# REDHORN CLOSE, POOLE

## INFILL SITES

### DESIGN & ACCESS STATEMENT

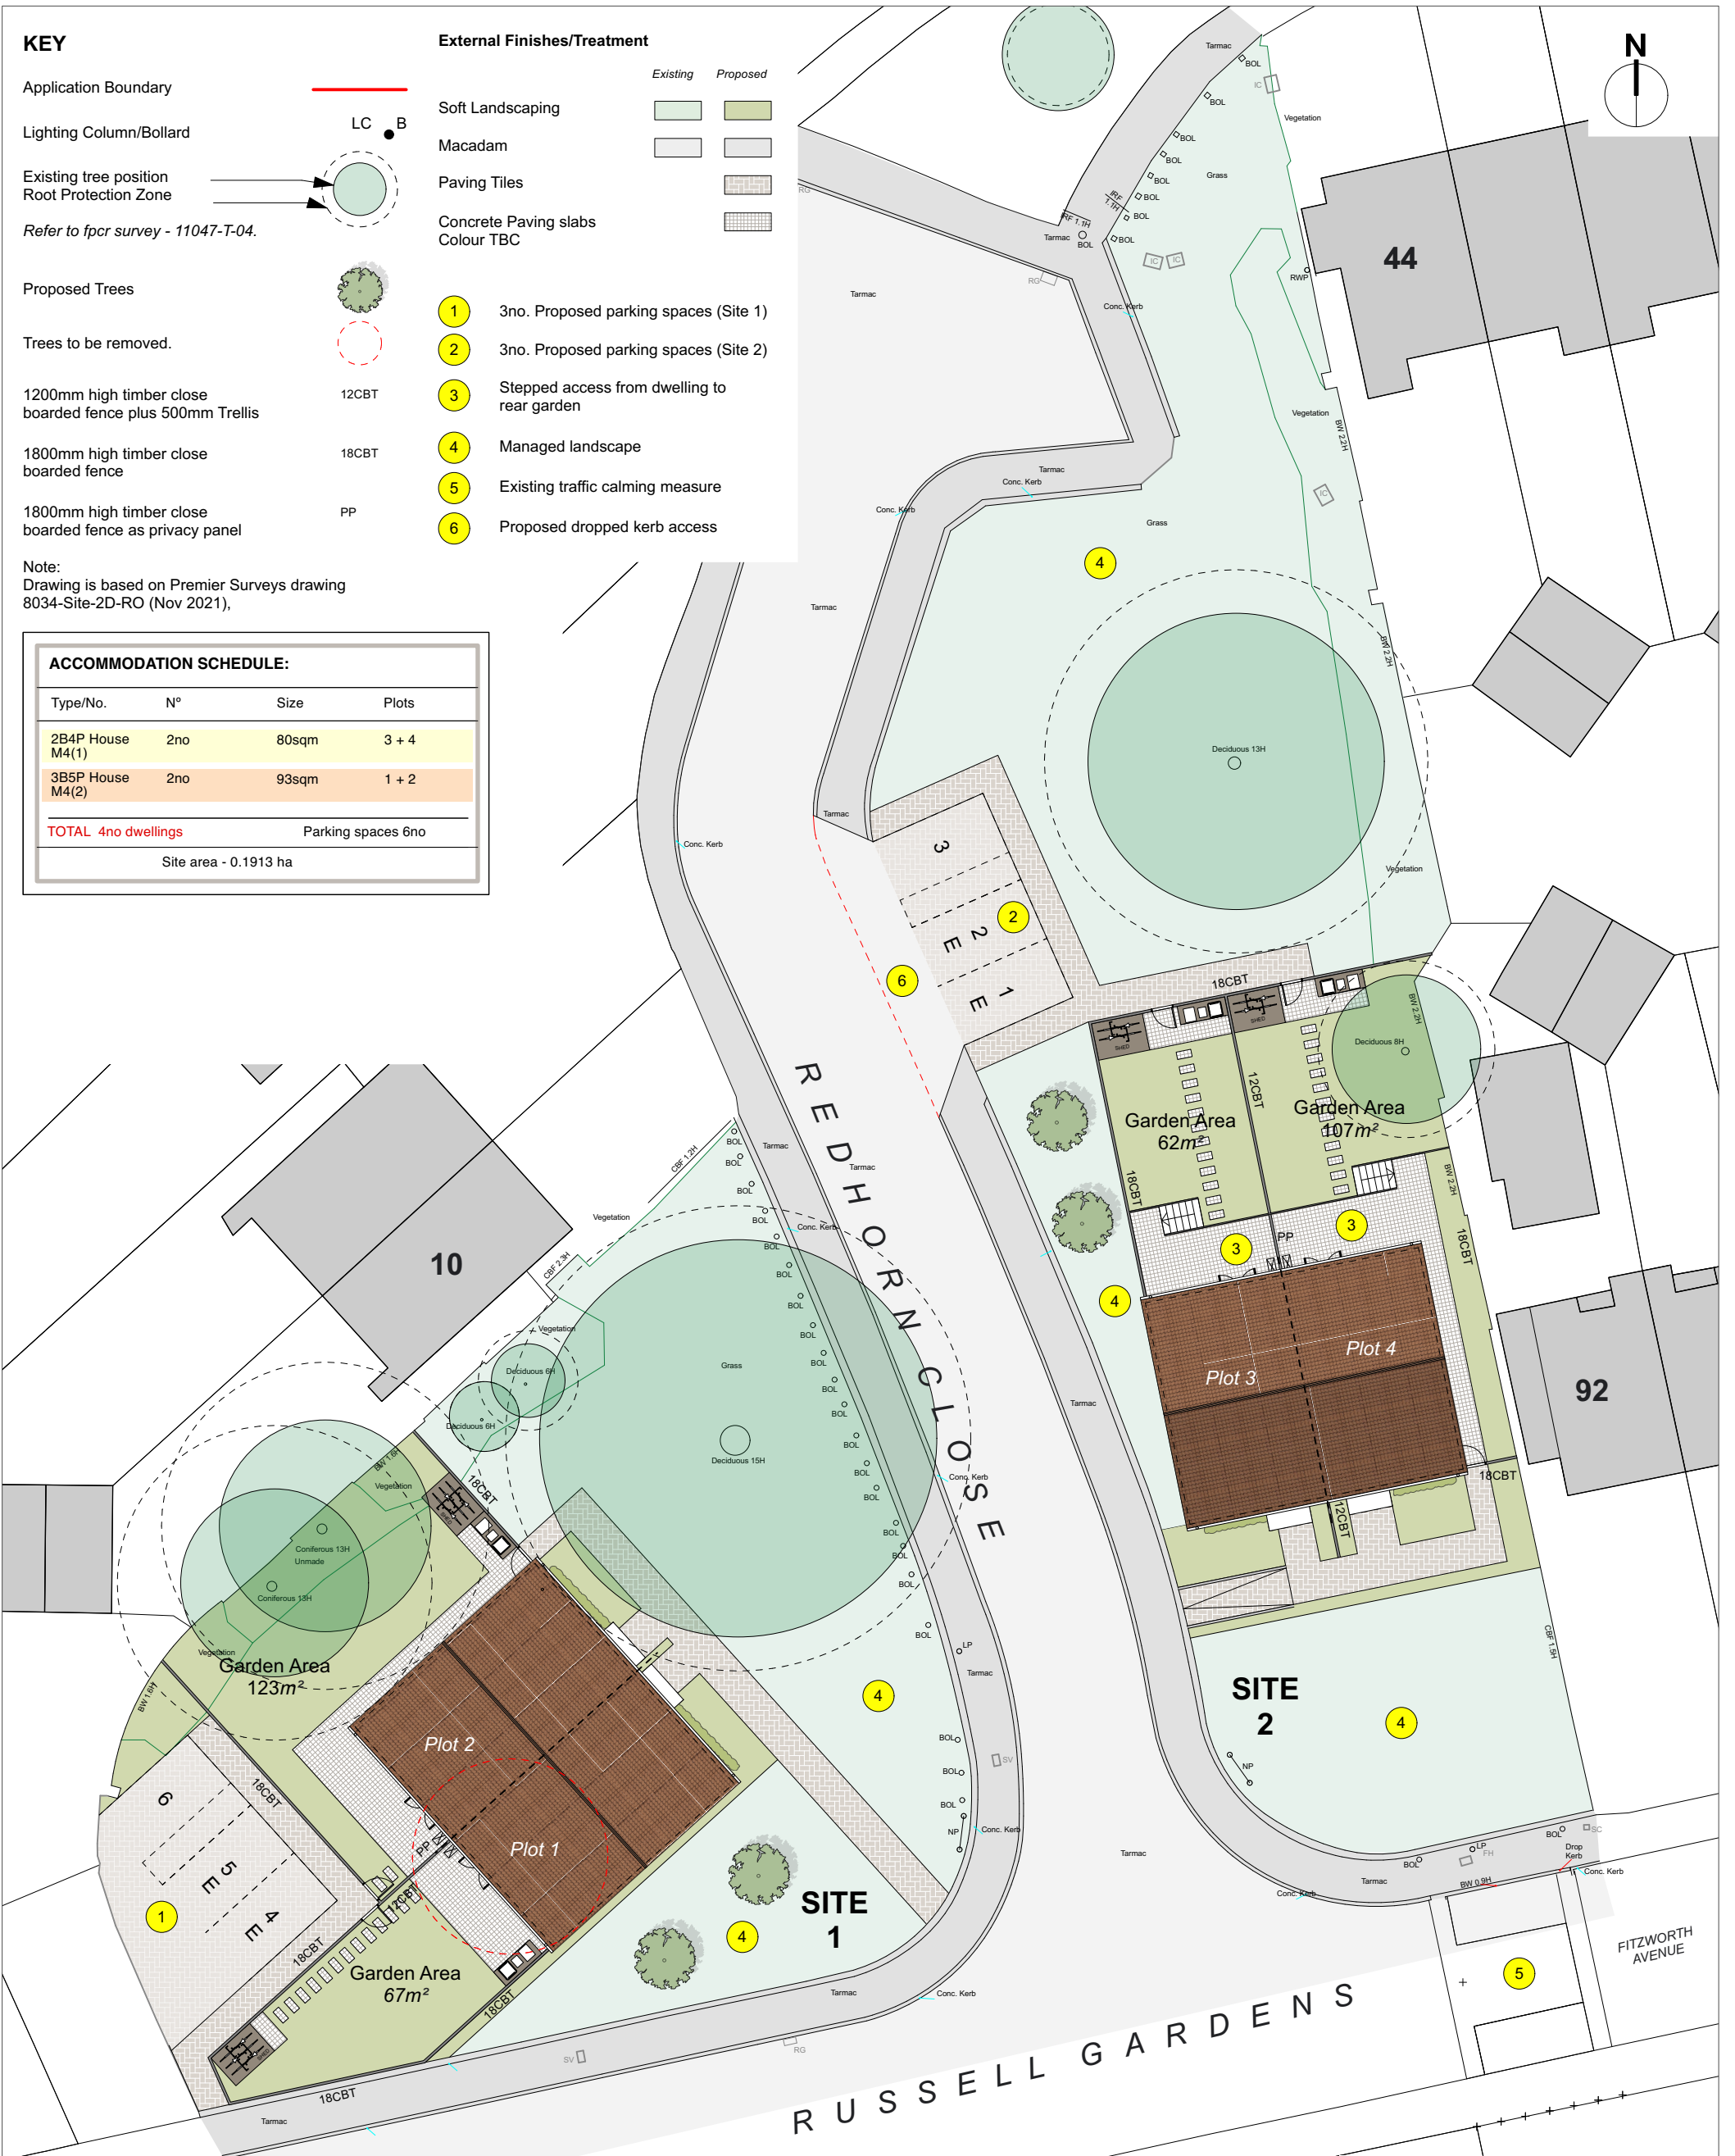
COMMENTS	RESPONSE
1	The application site is within the sustainable transport corridor and is therefore supported in terms of its sustainable location'	No response required
2	Recommendation that the building line (of site 2) is set back in line with the existing neighbour (Plot 92) and that the footprint is reduced to reflect that of its surroundings'	NDSS standards have been applied to each housing type, regardless, the housing density and layout as been revisited. A consideration of overlooking potential has adjusted the dwellings position within Site 2.
3	Concerns raised regarding building heights	See Pages: 27, 28
4	'Site 1 is contained by the trees and this arrangement would result in a cramped form of development'	Housing densities across both sites have been revised reduced from to ensure disturbance to the existing trees is minimised. As such the density of Site 1 has reduced from 4 properties down to 2, located sufficient distance from the RPZ of the existing mature tree.

5	'The proposed scheme, due to its location on the junction of Russell Gardens and Redhorn Close would result in a development that would erode the spacious and verdant character of the open spaces'	The reduced densities and ensured general visibility have ensured that the existing spacious and verdant character is maintained at the junction between Redhorn Close and Russell Gardens.
7	Concerns raised regarding overlooking	See Page: 26
8	Concerns raised regarding the RPZ's and impact on existing trees	The proposed scheme offers a reduced density and ensures RPZ and impact on the existing trees is minimised. Portions of the existing open green space is retained.
9	Highway safety concerns regarding perpendicular parking along Redhorn Close	Parking has been revised and reduced in line with the density reductions.
11	Compliance with adopted policies securing biodiversity enhancement, sustainability, drainage and renewable energy provision to be provided.	See Documents - EPS Energy & Resources Statement. Ref:15690d - SSP Drainage layout. Ref: 80640-03a - FPCR Tree Survey. Ref:11047-T-01 - KPEcology Ecological Impact Survey.
